# Comment for planning application 24/00539/F

TITLE:  
GENERAL ARRANGEMENT  
PART 2 OF 4

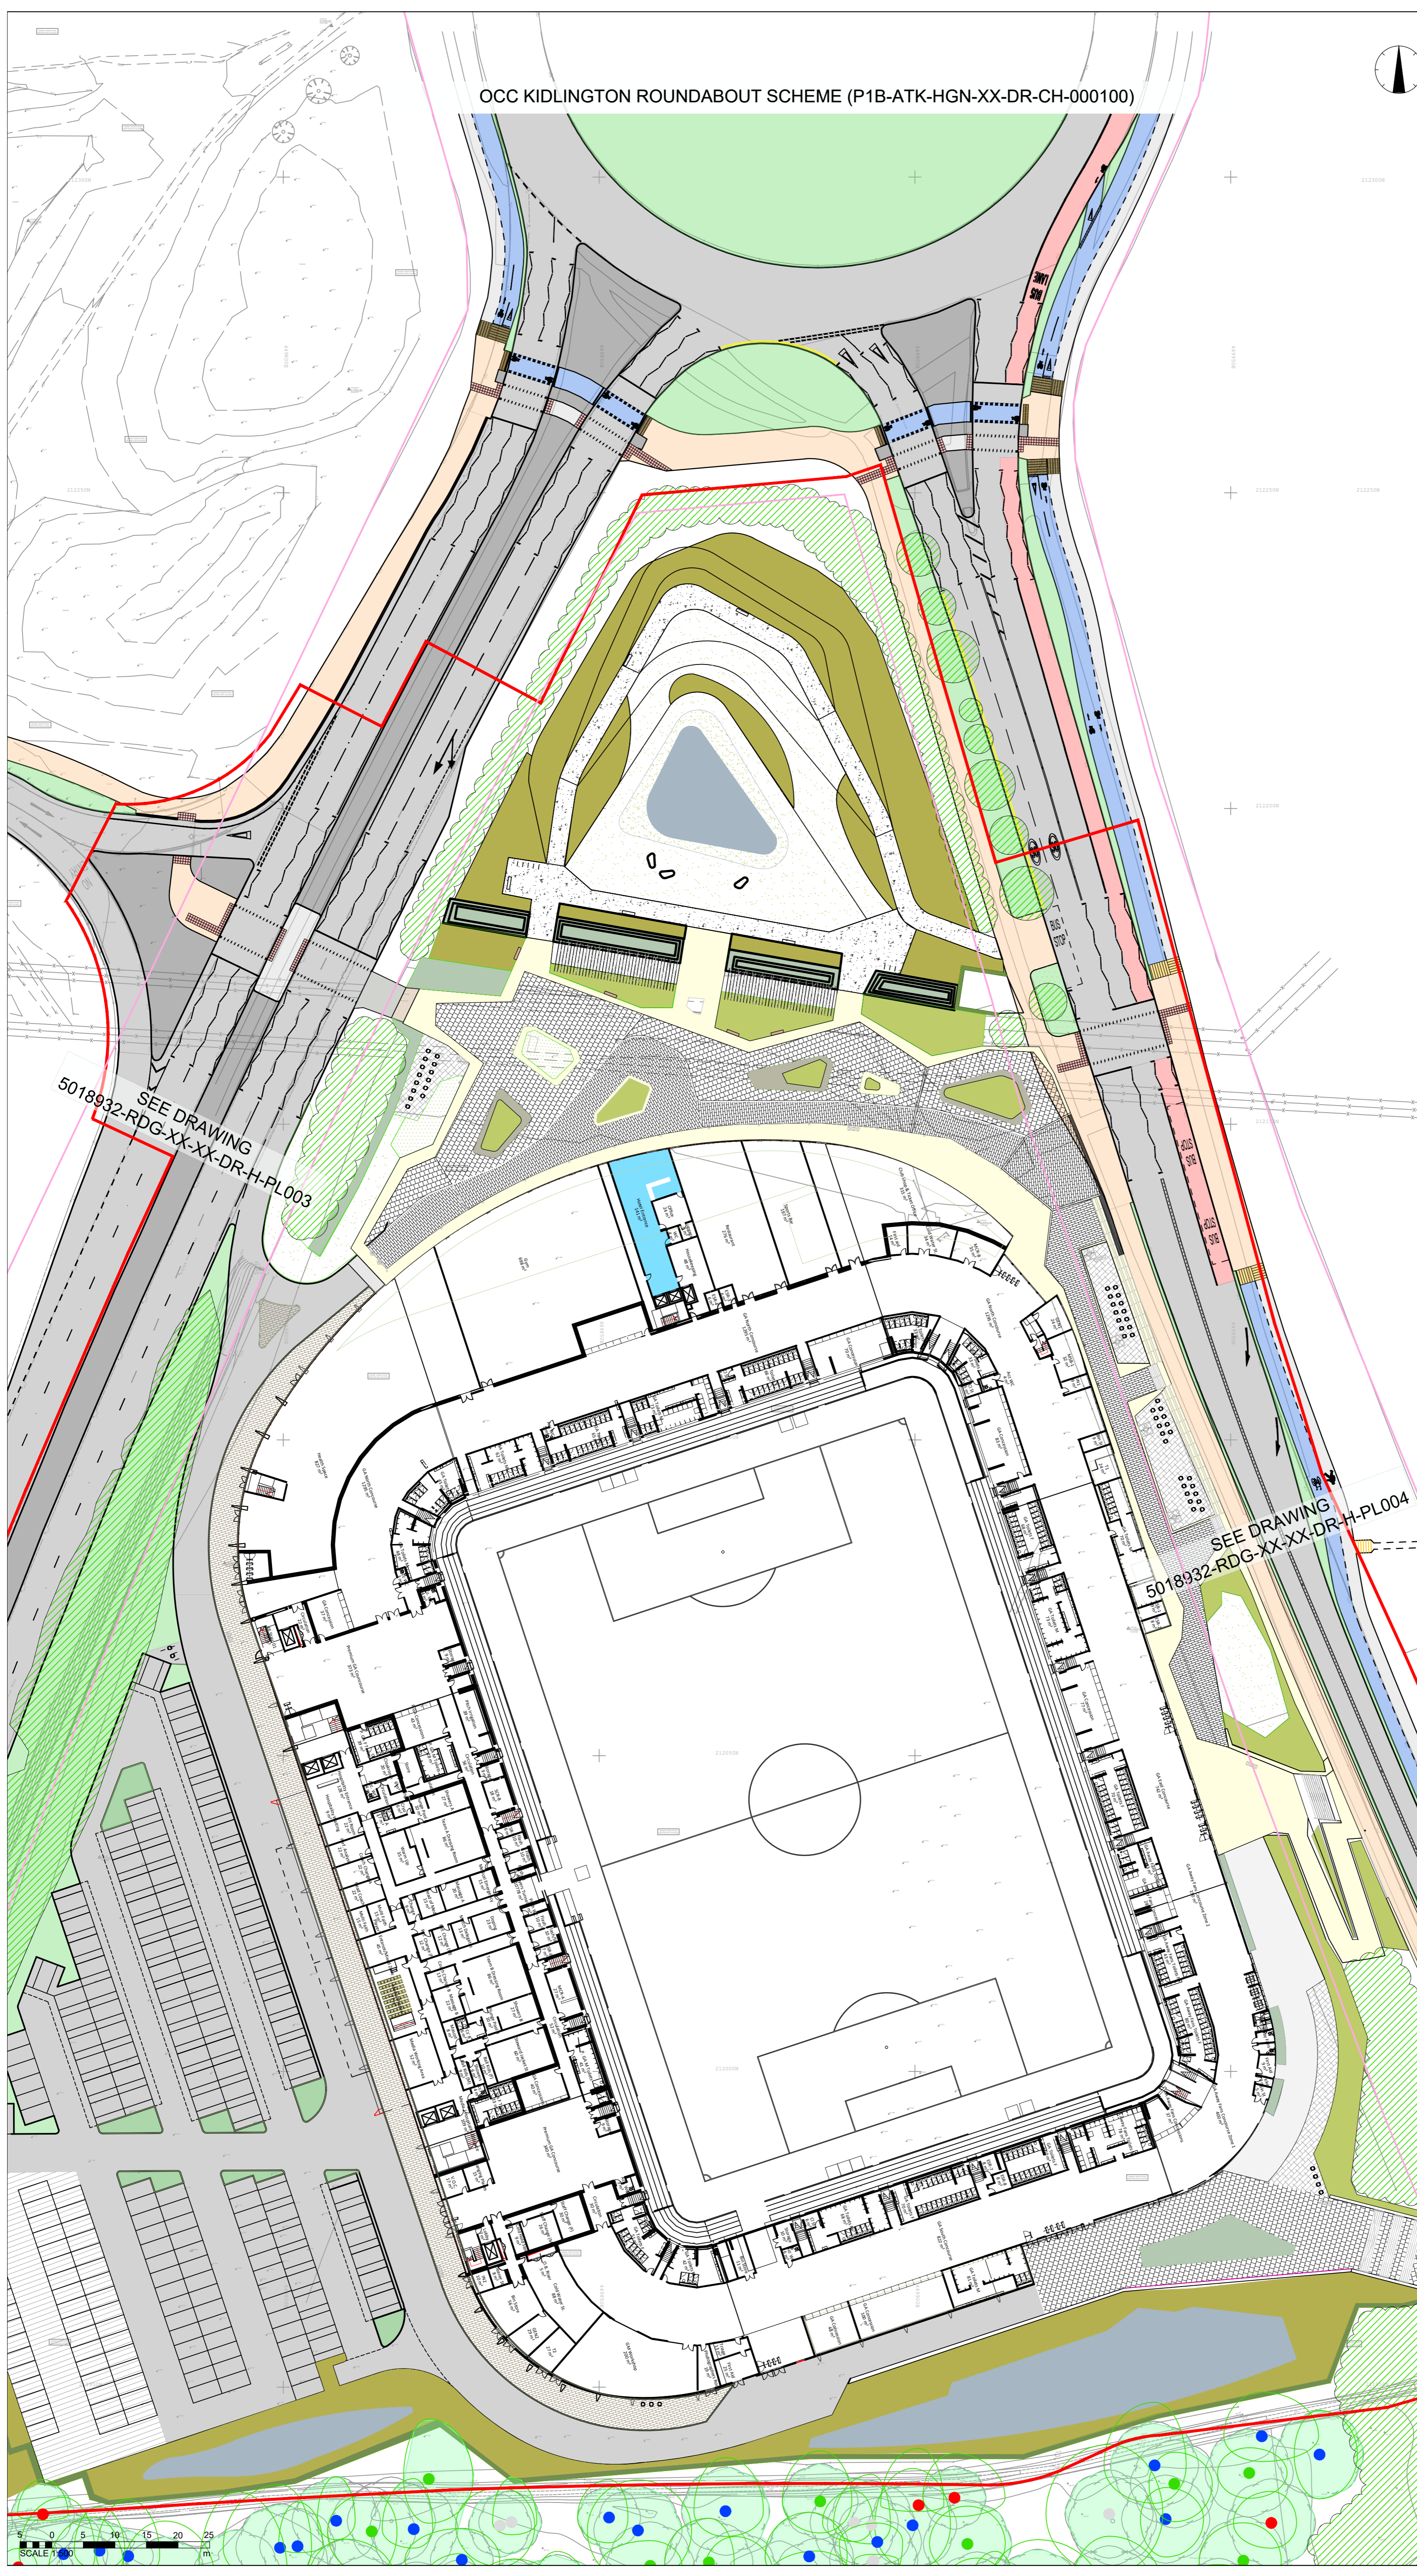
- i) Building dedicated safe cycle paths along both sides of the A4165 from the Cutteslowe to Kidlington roundabouts. The stadium proposal must not undermine cycle safety in this respect; in fact, it needs to be factored into the overall proposal.

- iii) Significantly re-designing Frieze Way to facilitate active travel (and better public transport). In the light of the stadium proposal and related developments, Frieze Way is rapidly becoming 'out-of-place' and unfit for its (revised) surroundings. Following the recent death of a cyclist on this road, Cyclox have set out some proposals for re-designing Frieze way, which can be found here - <https://www.cyclox.org/index.php/2024/03/07/what-can-we-learn-from-david-brains-death/>

TITLE:
**GENERAL ARRANGEMENT
PART 3 OF 4**

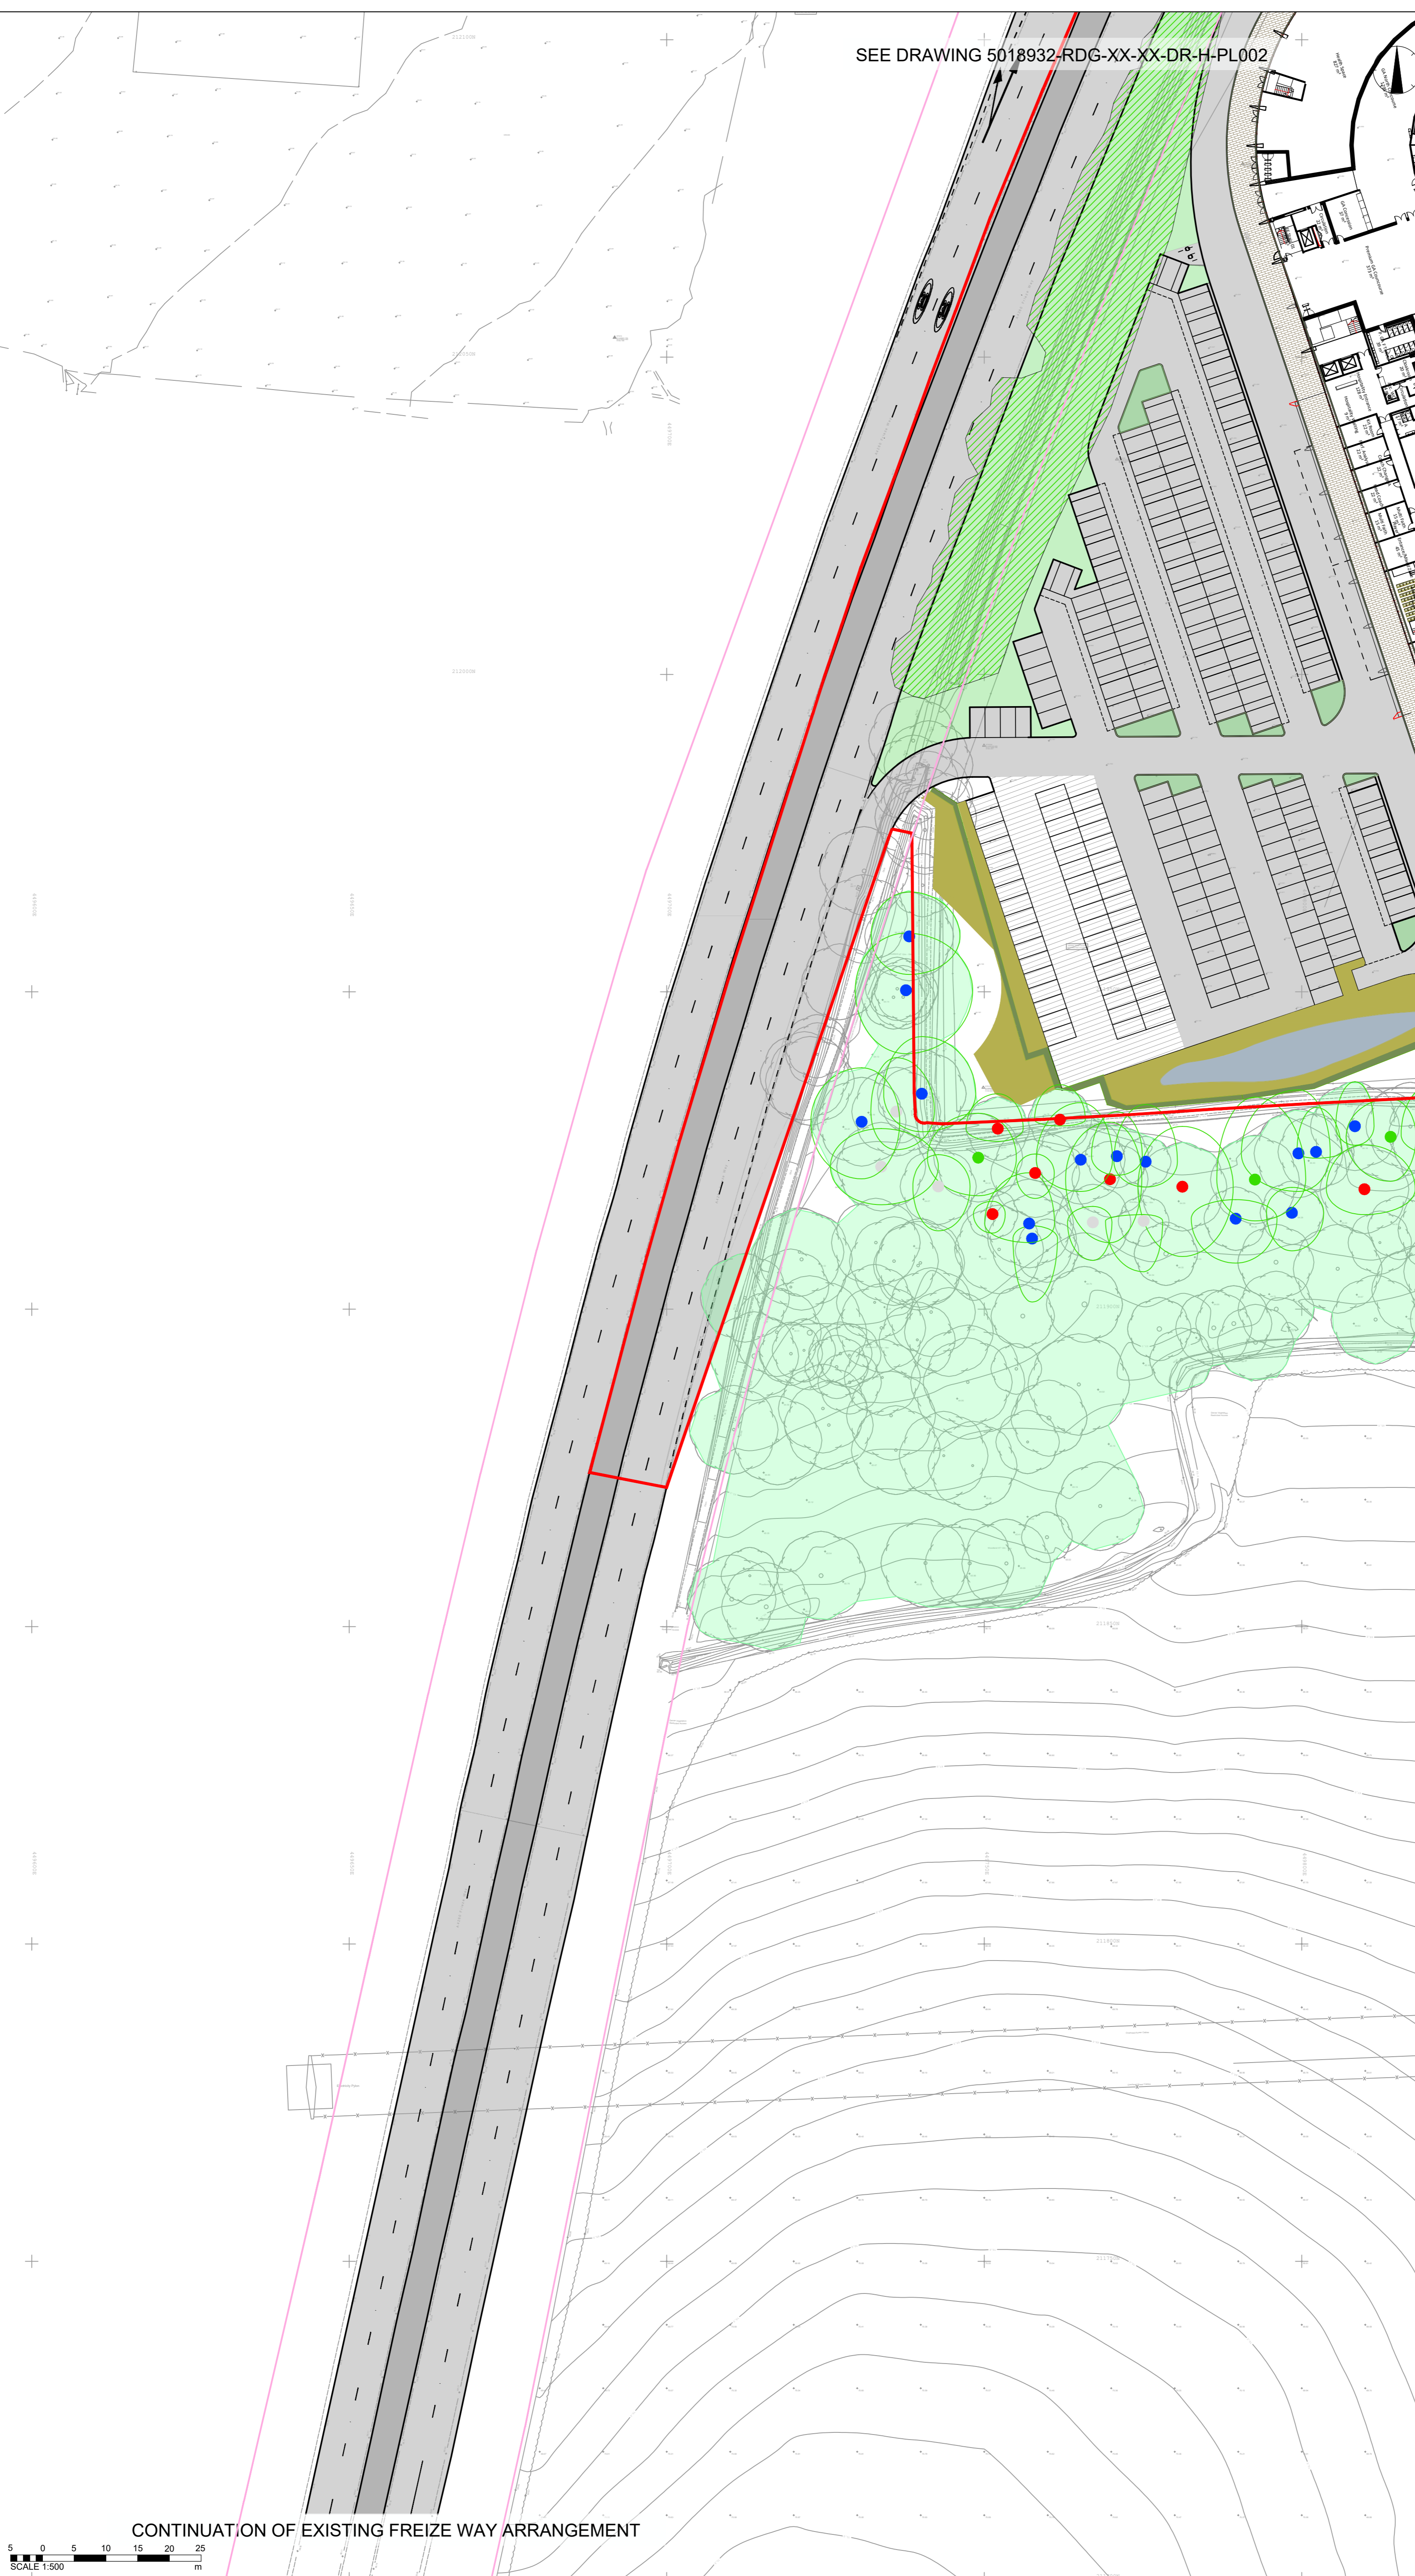
5. If you are intending to ensure more people cycle the proposed road closure will be a deterrent. There is no alternative route for people cycling whereas car drivers can be routed via the A44. Even if the road is closed to private cars it should be open to cycle riders.
